Application Correspondence "Response to proposed changes to the scheme"

From: Simon Davis
Sent: 29 April 2021 14:37
To: Megan Green [REDACTED]
Cc: Chris Brake [REDACTED]
Subject: RE: AL/20/21/PL - Wings Nursery, Lidsey Road, Woodgate

Appendix 6 - development proposal plan

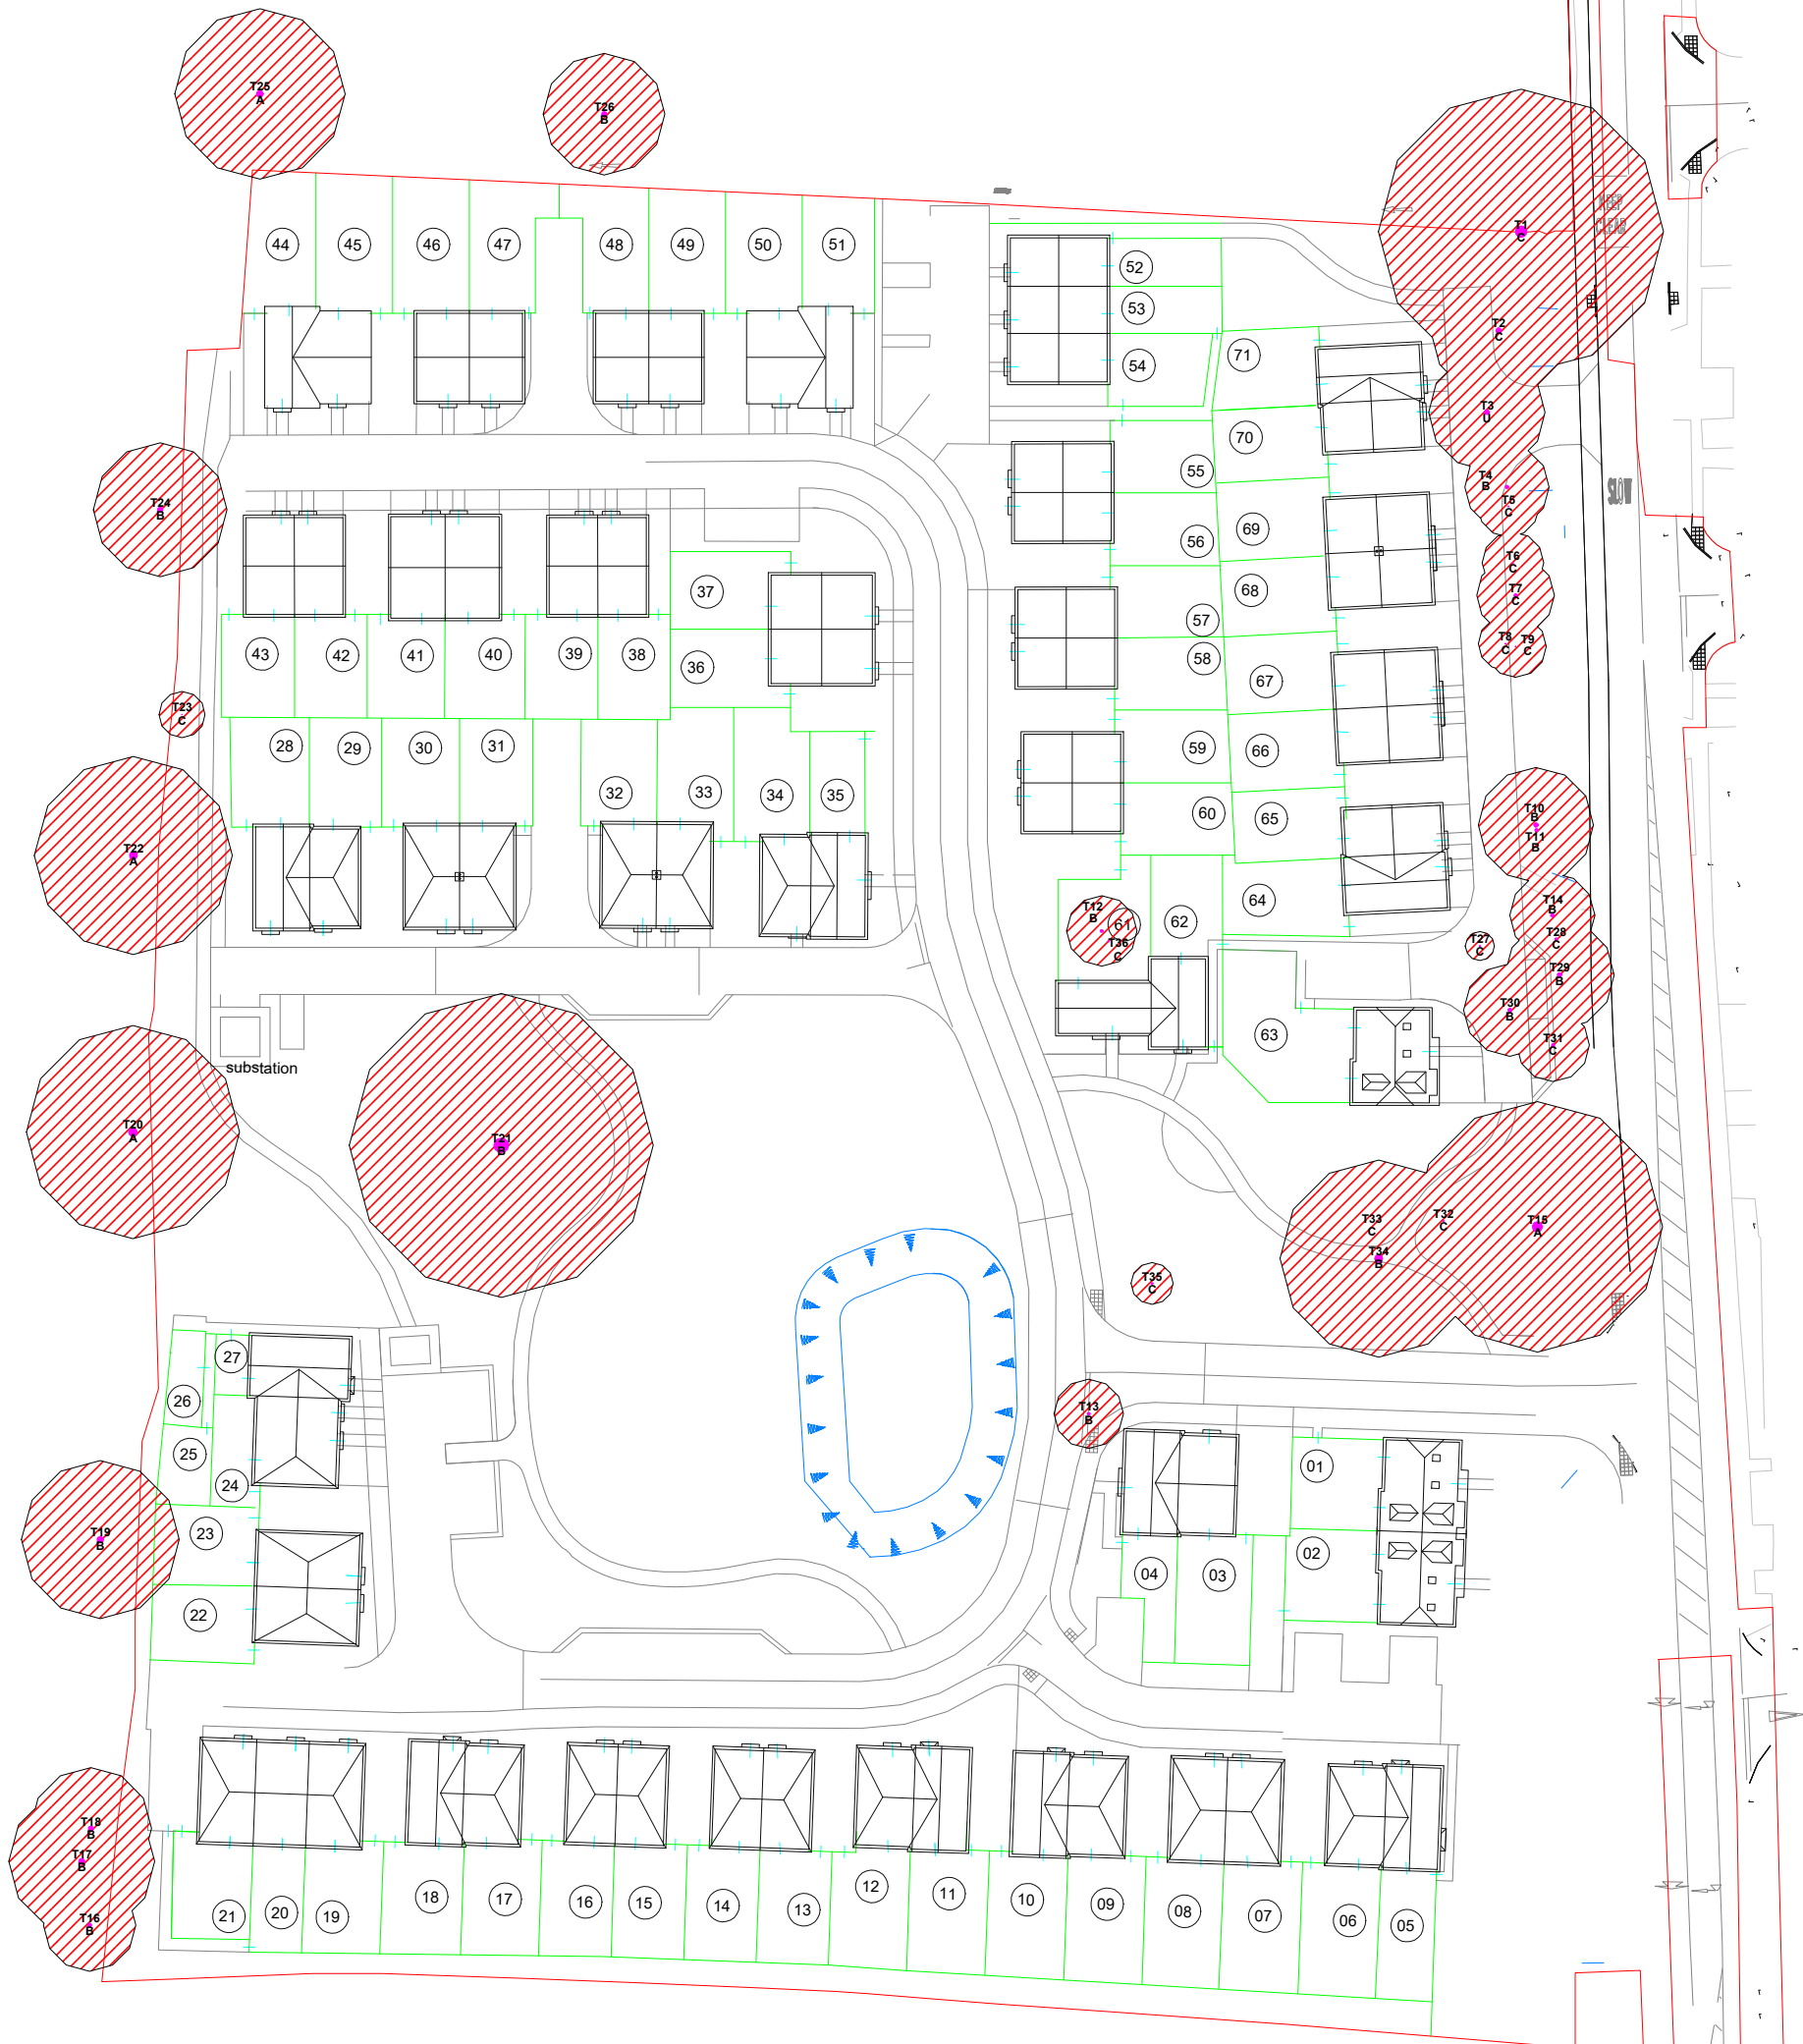
We have now reviewed the submitted drawing and in our view the changes that you have made to the northern part means that it works much better now. In relation to plots 61-63, the gable end of 61 will be important. If you can provide some good openings on this elevation, then this will be ok.

Thanks for your comments on the interface distances. I am happy to go with your measurements as I don't have the benefit of a paper copy and so only have the ability to measure using our website tool. Please can you ensure that the same comments are made clear in the resubmission (covering letter?) so that I can easily find them if I need to refer to them when writing the report. In respect of your question re plot 21, I am happy with your proposal to shorten the depth given the garden's width.

In respect of the street trees, this point was made in respect of those trees sandwiched in between parking spaces particularly prevalent in the northern part of the site. The changes made have resolved many of these (through their removal from the scheme). However, please look at those street trees to the side of plot 51, front of plot 55, side of plot 37 and side of plot 35. Those to the front of plot 10 and side of plot 2 seem to have plenty of room to grow as do those within the POS areas.

- *Make plots 44-47 all front south onto the road (so have the same building line as 48-51). Plots 44-51 should then all have on-plot parking. **We propose to amend plots 44 to 51 from two sets of terraces to four sets of semi-detached dwellings with individual on-plot parking. A turning heading is proposed between plots 47 and 48 to enable refuse and fire access.***

- *Redesign the arrangement of plots 61-63 so that all three front onto a road and have on-plot parking. **Having reviewed this area in detail we feel the comments apply to plots 61 and 62 only. In design terms we feel it is appropriate that plots 61 and 62 front onto the open space in order to provide both natural surveillance and a welcoming street scene as you enter the development, opposed to a side elevation and parking if plots 61 and 62 were reorientated. We feel the parking for 62 being 'tucked away' provides a better street scene and that residents are more likely to use designated private parking spaces rather than parking on the main spine road of the development. Whilst we are not proposing significant changes, we have added a footpath between plot 62's parking space and front door to demonstrate a commitment to ensuring easier access for plot 62. Plot 61's parking is the same as Plots 1 & 2 (and others) where driveways are located at the end of rear gardens. We are of the view that plots 61 and 62 as currently drawn both have good quality amenity space and outlook outside their front and we would like to maintain this.***

- *plot 37 rear to 38's side is 12m (2m shortfall). We have measured this to be 12.7m (1.3m shortfall) and as plot 38 sits to the west / north west of plot 37 we do not believe this minor shortfall impacts on light or overlooking.*

- *some rear-to-rear distances are in the range of 20-21m (so up to 1m shortfall) Plots 54 & 71 were the shortest, at 20.7m so 0.3m short – we are proposing to move plots 64-71 0.5m eastward to increase back to back distances. 54 and 71's distance will then be in excess of 21m.*

- *plot 19 front to 22's side is 10m (4m shortfall) We have reviewed this area in detail and whilst plots 19 and 20 have gardens in excess of 10.5m deep so would be able to move south to increase distance to plot 22, plot 21 is 10.5m due to the requirement for rear garden access to plot 20. As plot 21 has a wider garden, please advise whether you would be open to considering plots 19-21 moving south to increase the distance to plot 22 but with plot 21's garden depth being non-compliant with the design guide (by c.1m).*

- *plots 40/41 front to 44's side is 8.4m (5.6m shortfall) This would be resolved by the redesign of plots 44-47.*
 - *plots 36/37 front to 57/58's front is 12.3 (3.7m shortfall) We propose to amend plots 38, 39, 42 & 43 to C2H4 (narrower house type) to gain 2 metres. We then propose to move Plots 36 and 37 west by 2m to increase the front-to-front distance to plots 57 and 58 which will also allow additional planting.*

- Relocate the substation or better screen it so that no house directly looks out onto it. We have proposed to move the substation further south and have added additional planting for screening.

- *Increase the space for street trees. We will review the tree position locations circled red as part of the site layout update once the above changes have been agreed.*
